Application for a Non-Material Amendment Following a Grant of Planning Permission

Submission of Details (Reserved Matters) Application for Outline Planning Application DC/21/03012 Allowed at Appeal APP/W3520/W/21/3282019. Appearance, Landscaping, Layout and Scale for the erection of 2no dwellings, associated garaging and new vehicular access to highway.

DC/23/05779

Change of wording to condition 2 to omit reference to black cladding and replace this with the reference natural larch cladding.

Title  
**Plot 2 Plans as Proposed**

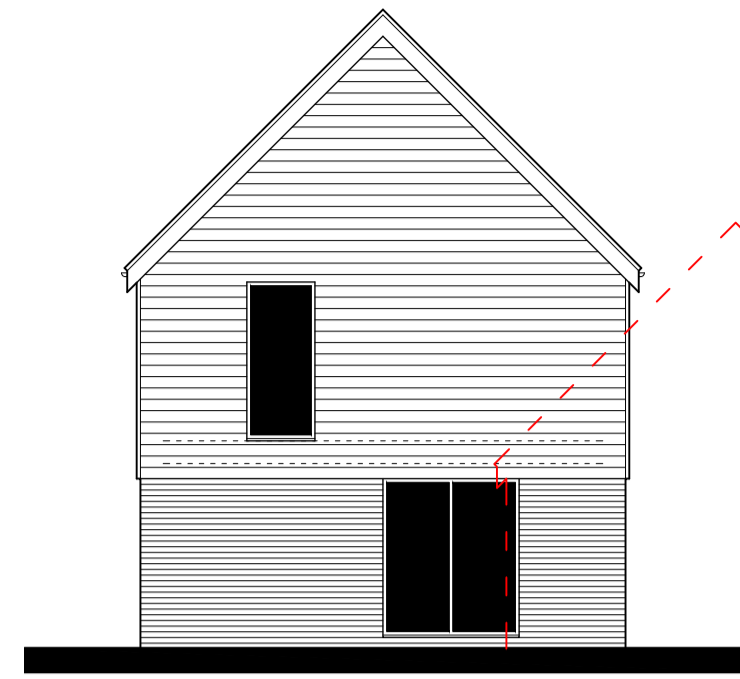
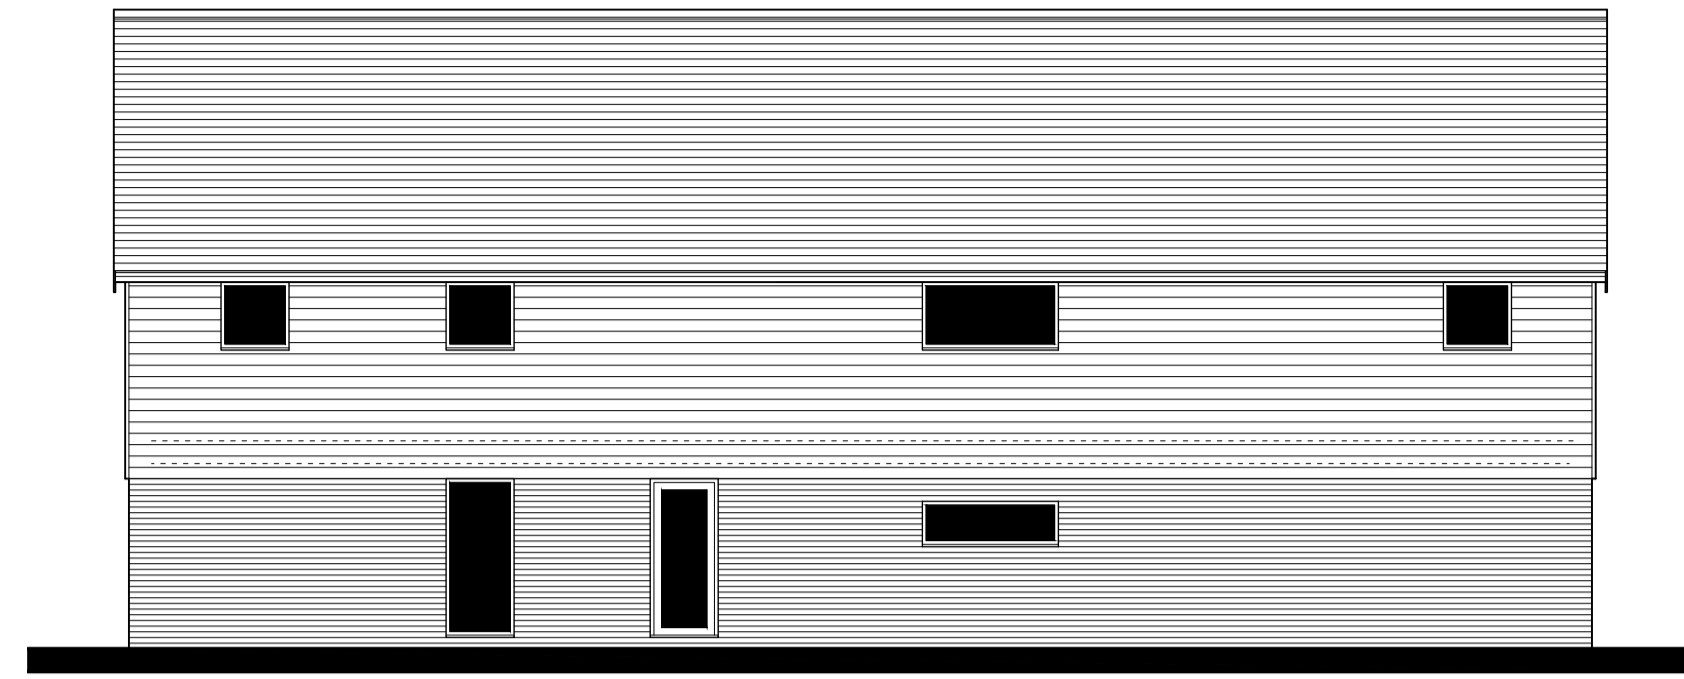
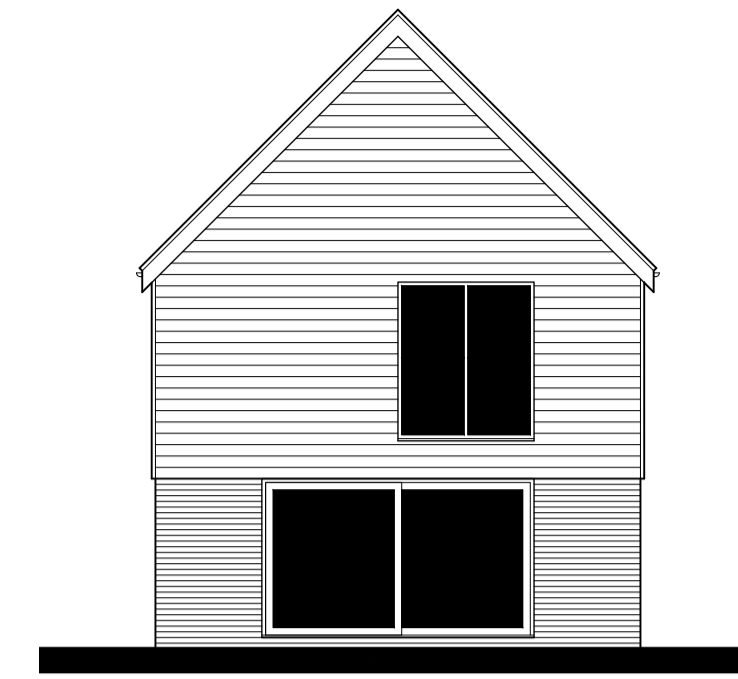
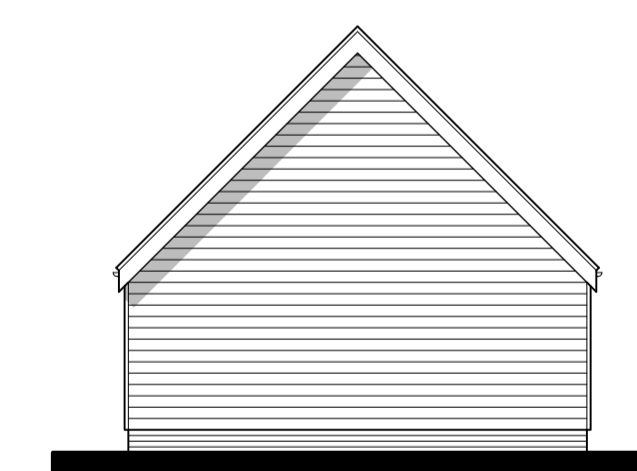
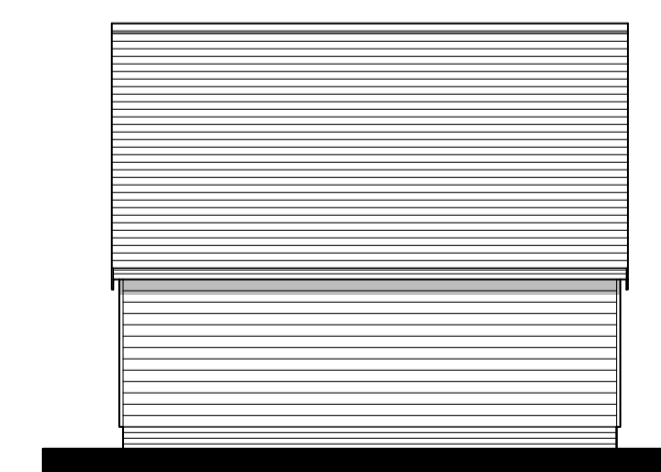
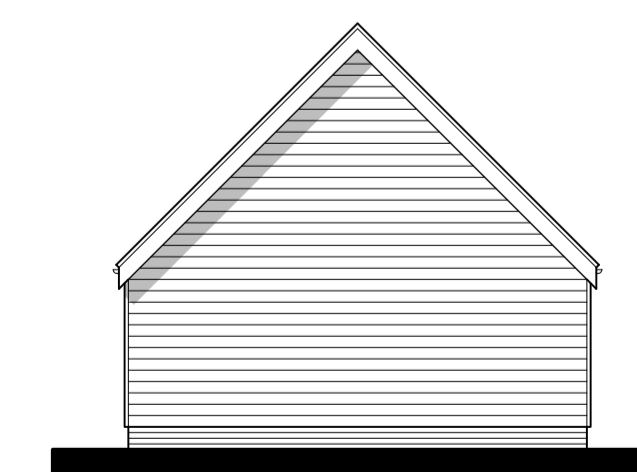
The use of natural horizontal larch cladding and the general appearance was discussed and agreed at pre-application stage. The change to black cladding was not discussed or agreed prior to the planning decision being issued. The use of black cladding in this scenario is not conducive with the proposed designs.

554-02 rev G Plot 1 Plans as Proposed
554-03 rev F Plot 2 Plans as Proposed
